Recommendation Report for Planning Permission for Works or Extension to a Dwelling

REF NO: BR/120/20/HH

LOCATION: 32 Victoria Road
Bognor Regis
PO21 2JF

PROPOSAL: Demolition of existing garage and addition of a proposed annex.

130-01-14

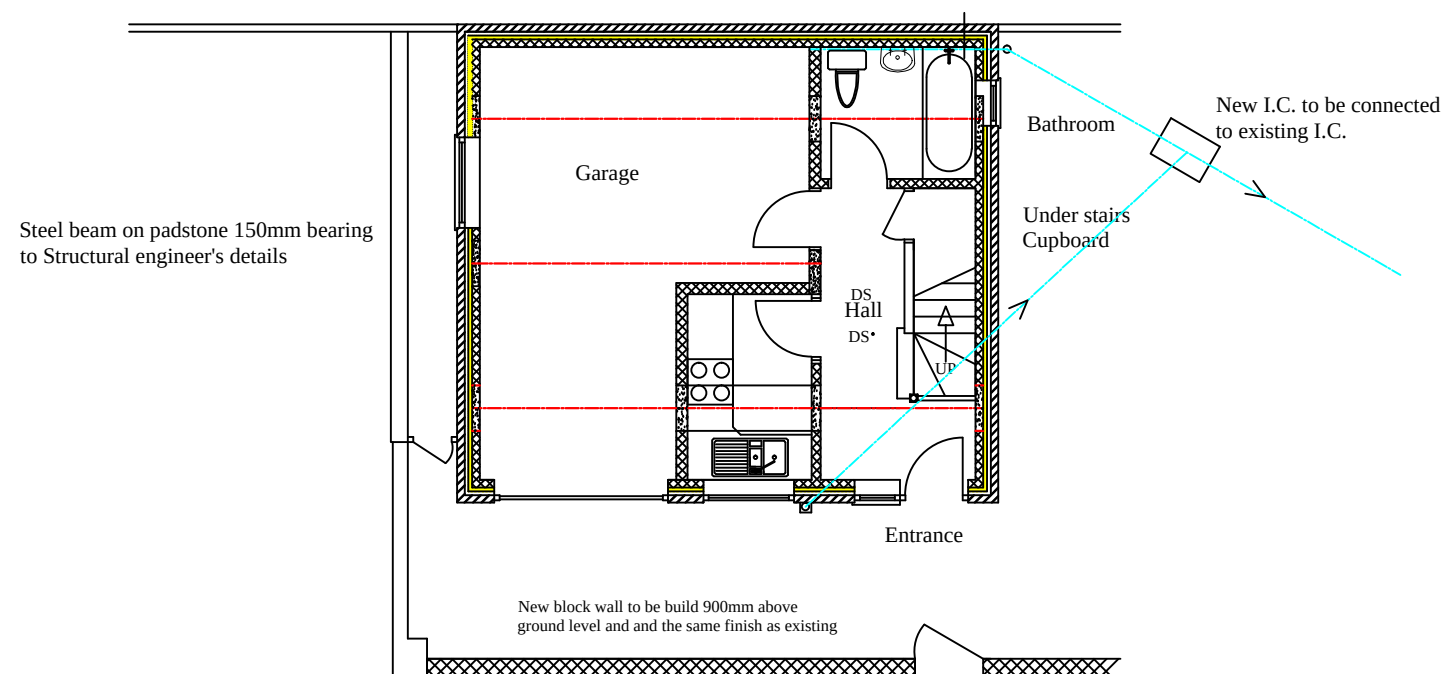
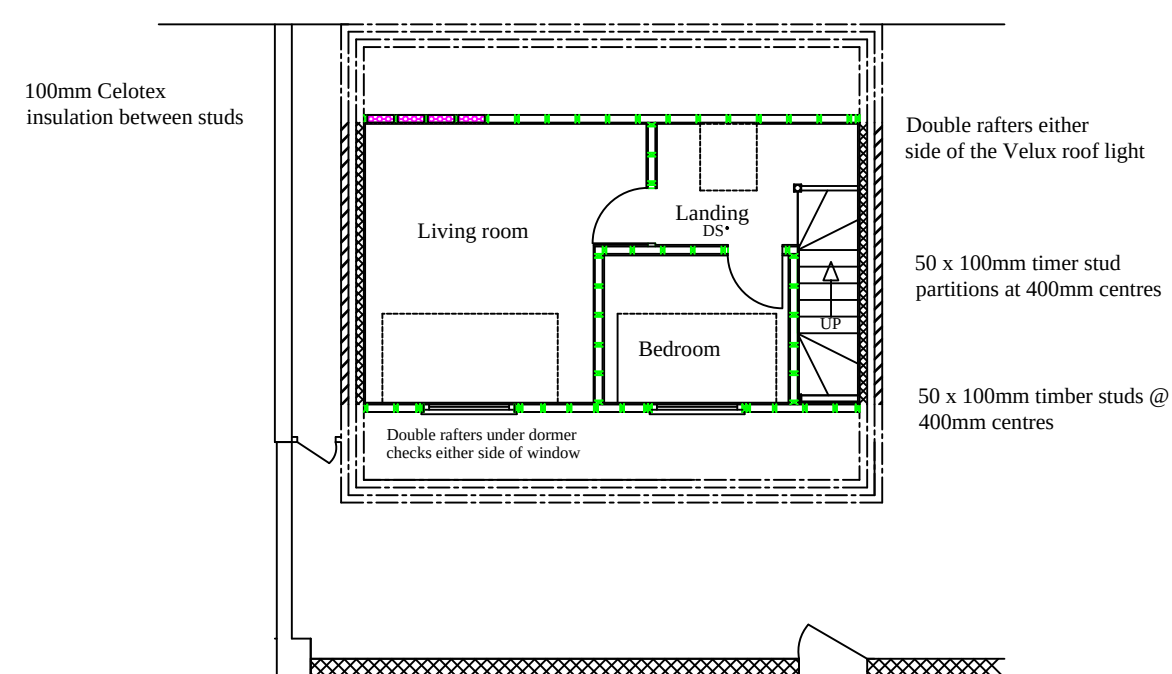
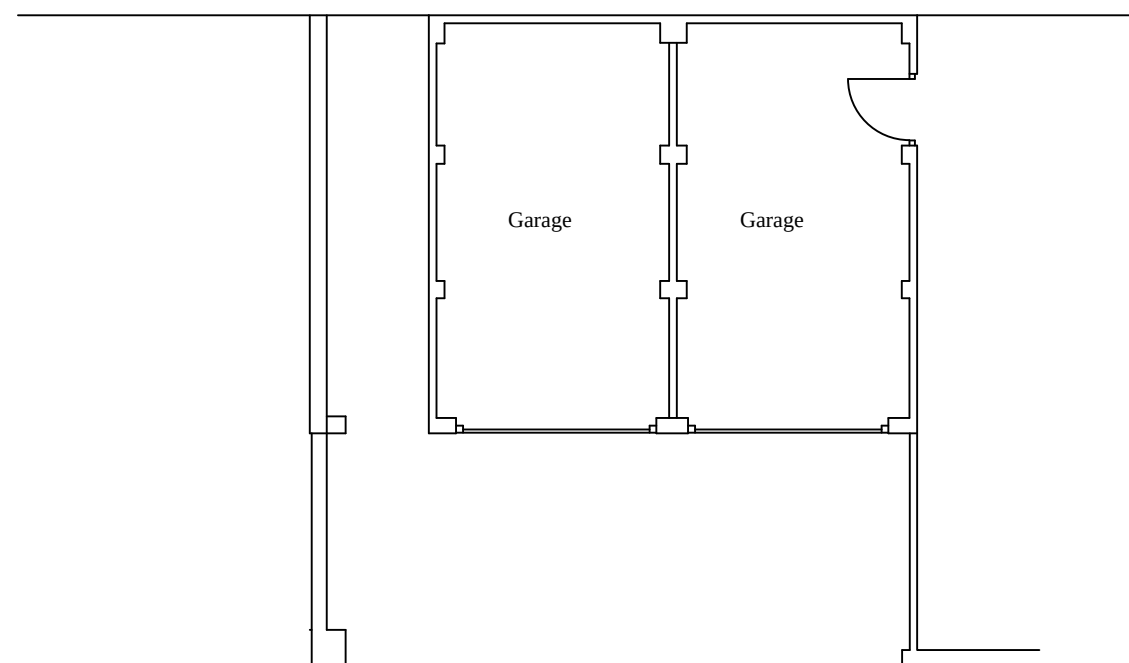
The existing double garage will be replaced with an outbuilding that will serve as an annexe, with a single garage to the ground floor.

The proposal retains 1No. parking space within the ground floor garage. Whilst this would lose 1 garage space it is not considered to result in an adverse impact upon the highway and it is unclear whether it is currently used a parking or storage.

It is considered appropriate to restrict the use of the garage area so that it is not used for residential accommodation in the future without the consent of the Council to ensure the implications of any larger living space and further loss of parking can be assessed.

- 5 The proposed garage as shown on the approved plan, 130-01-14 (2/6/20) shall only be used for the parking of vehicles or storage related to the residential use of No. 32 Victoria Road, Bognor Regis and shall not be used as additional residential accommodation in the annex without the prior approval, in writing, of the Local Planning Authority.
